Subject: A/84/21/DOC

I refer to Application A/84/21/DOC. I realise this is a Discharge of Conditions application upon which you would not normally invite public comments.

My comments upon **Condition No 23** – maintenance and management of sustainable drainage scheme (SuDS) are:-

Figure 2: Proposed detail of access road and culvert, including upstream and downstream step access to watercourse.

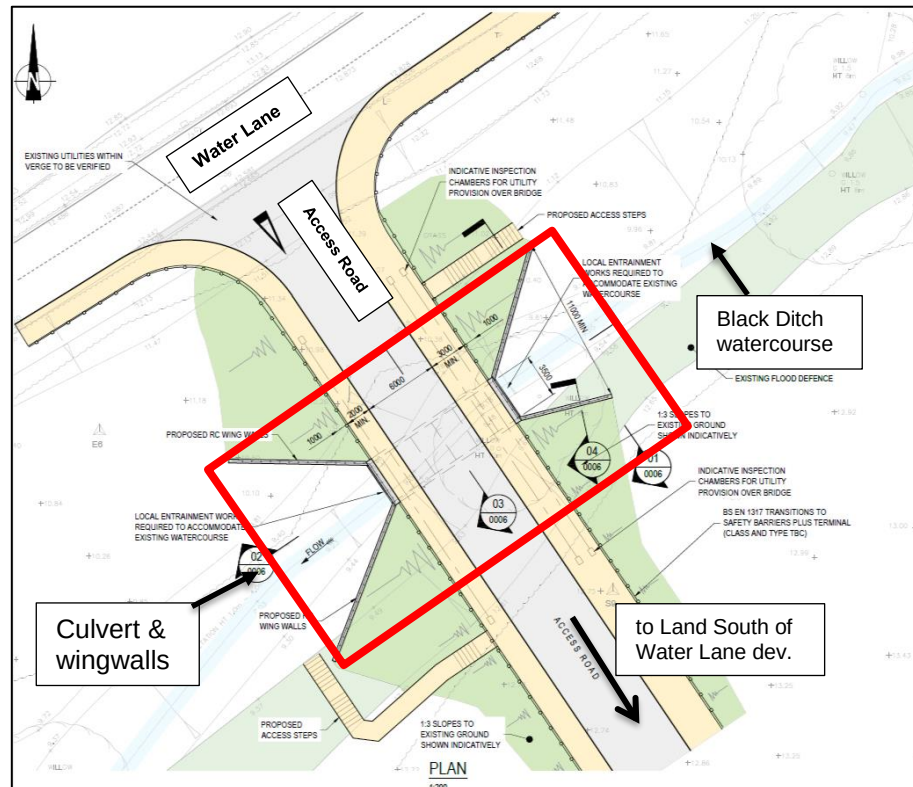
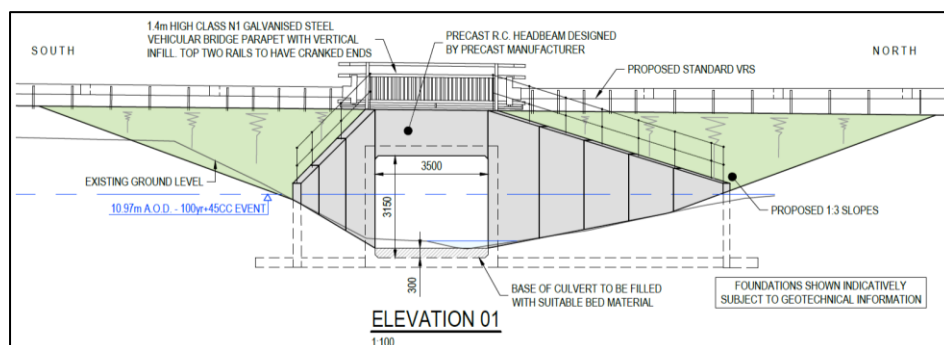
My comment upon **Condition No 26** – future access and maintenance of any watercourse or culvert is that it needs to be clear as to who will do what. Will the embankment upon which the access road is built and through which the culvert flows with its associated flow control equipment be a highway structure?

Title
**DRAINAGE MAINTENANCE
PLAN**

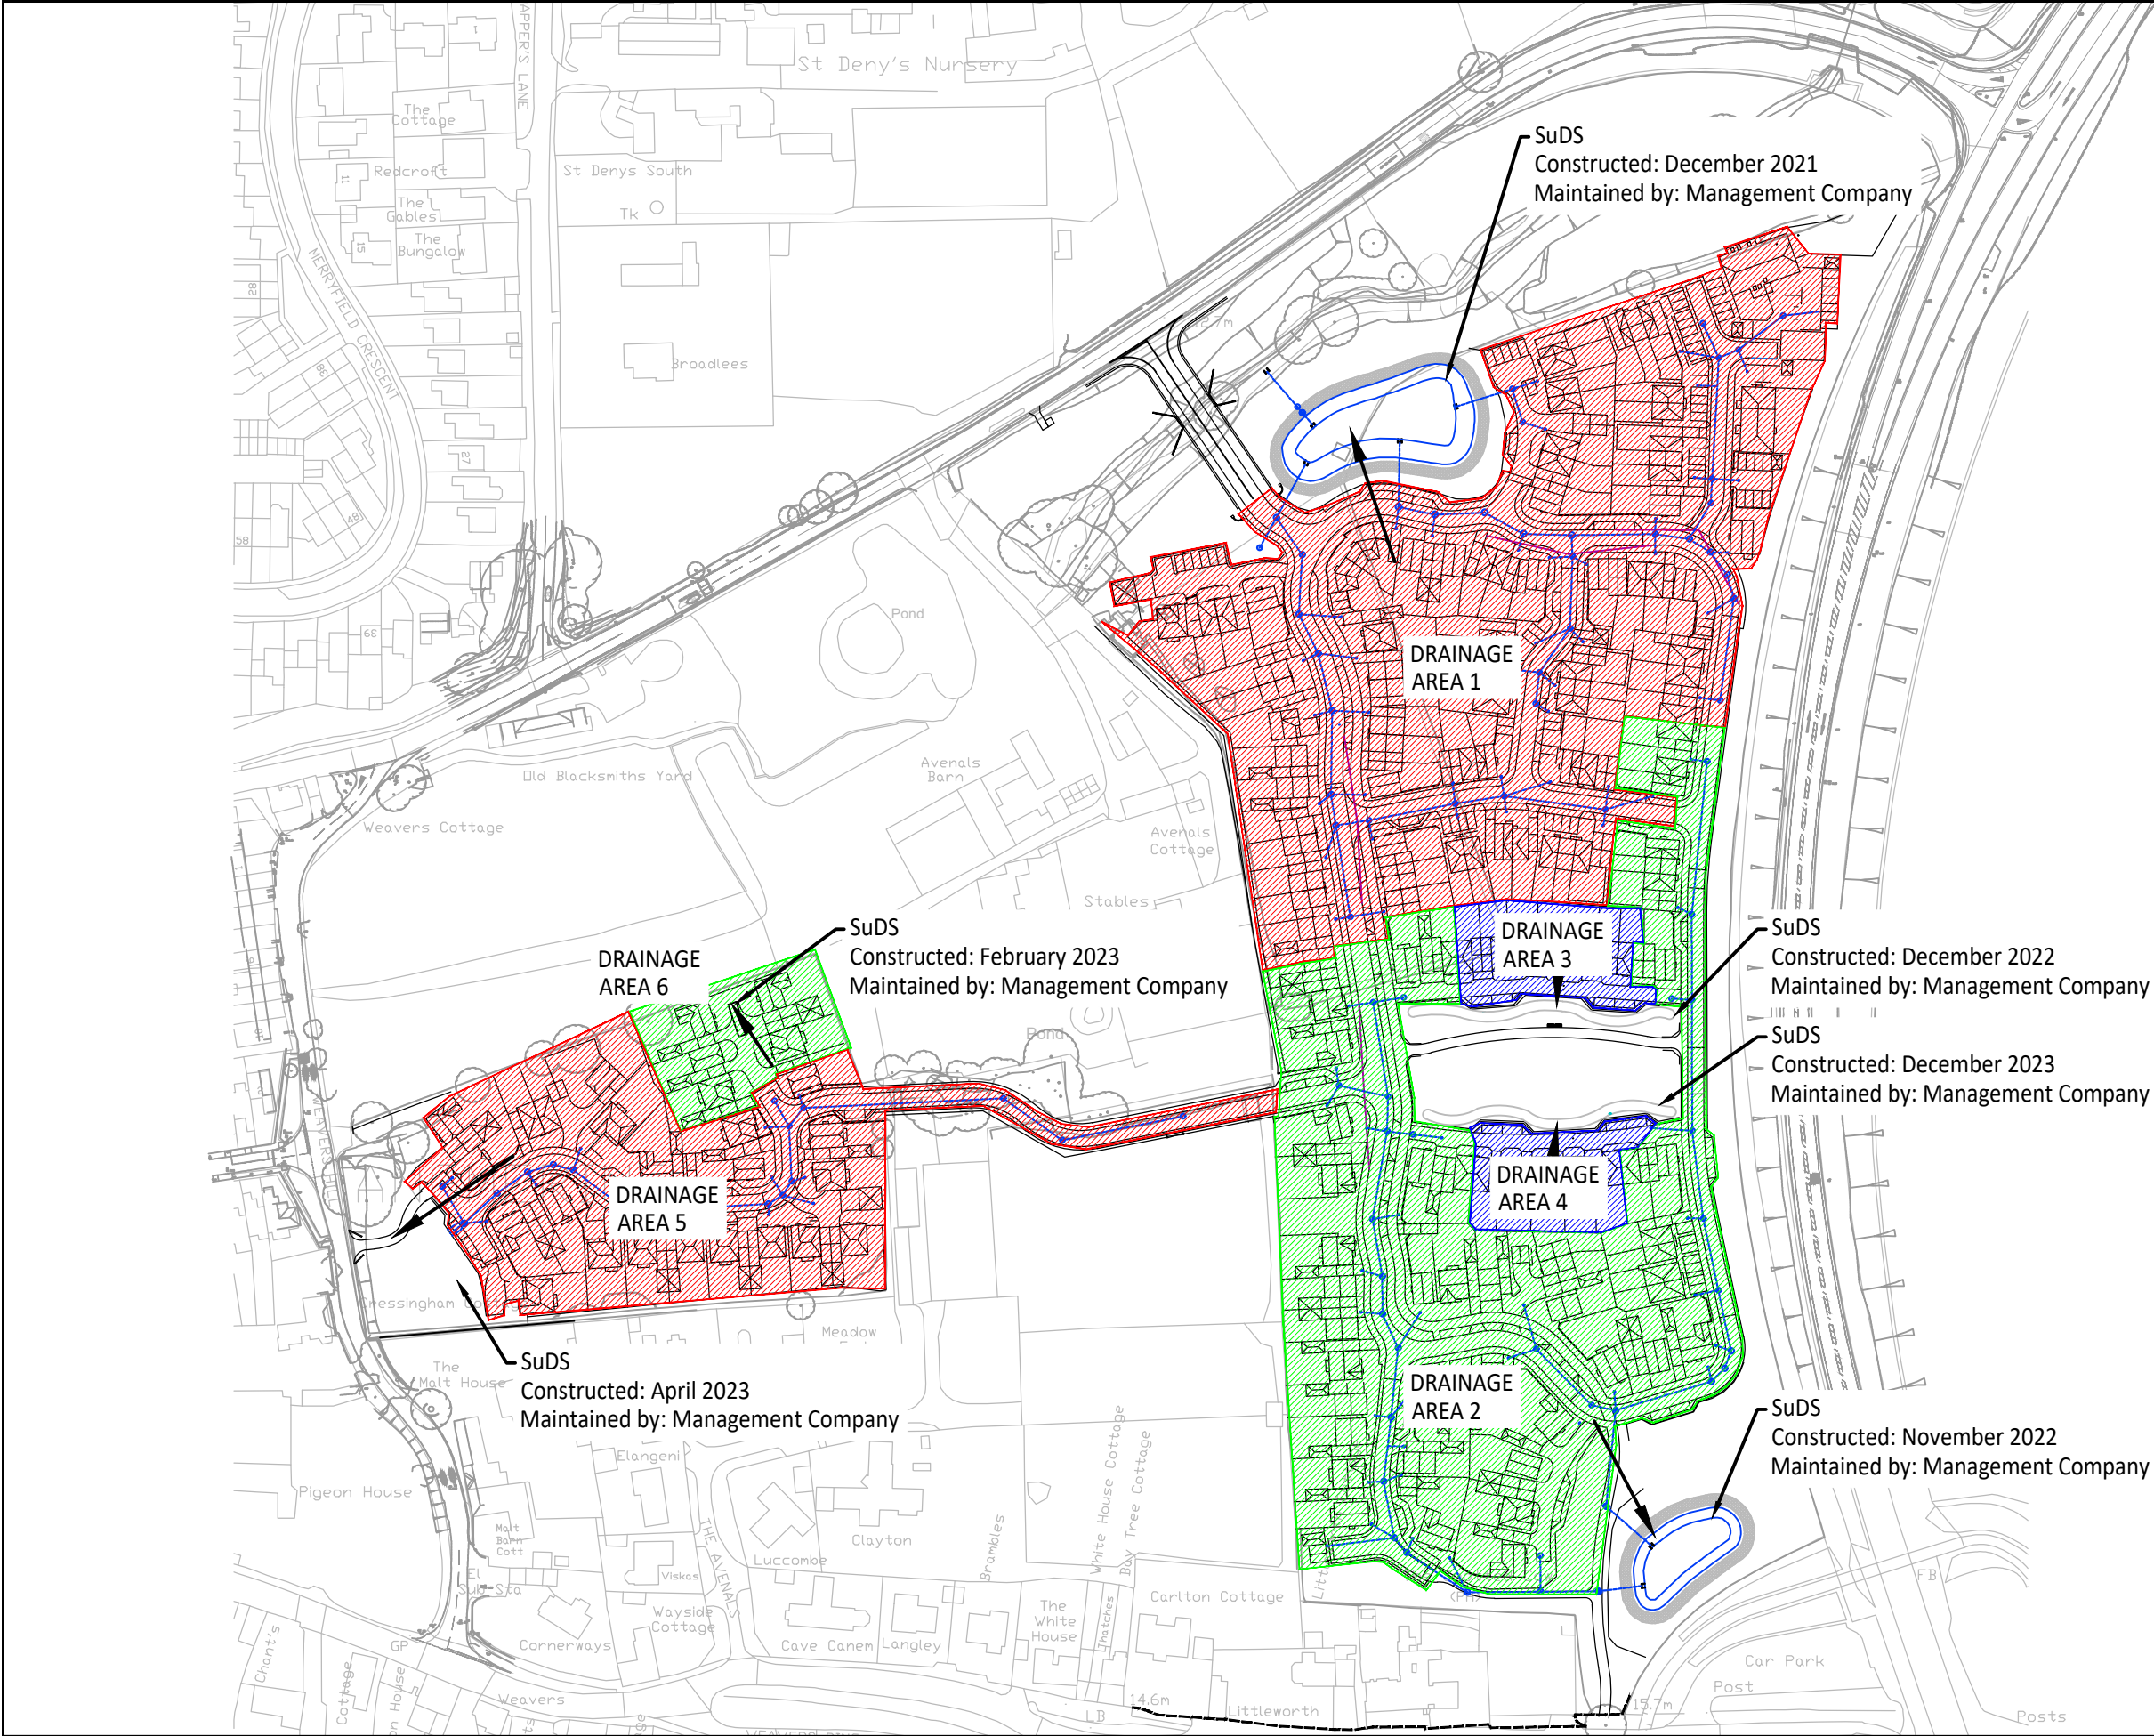
I am unclear as to who will operate and maintain this flow control device. My assumption is that it will be the LLFA because of their involvement to date. However, this is a Main River, where the Environment Agency would normally manage flows for flood risk purposes. Indeed this flow management structure will require permission from the Environment Agency.
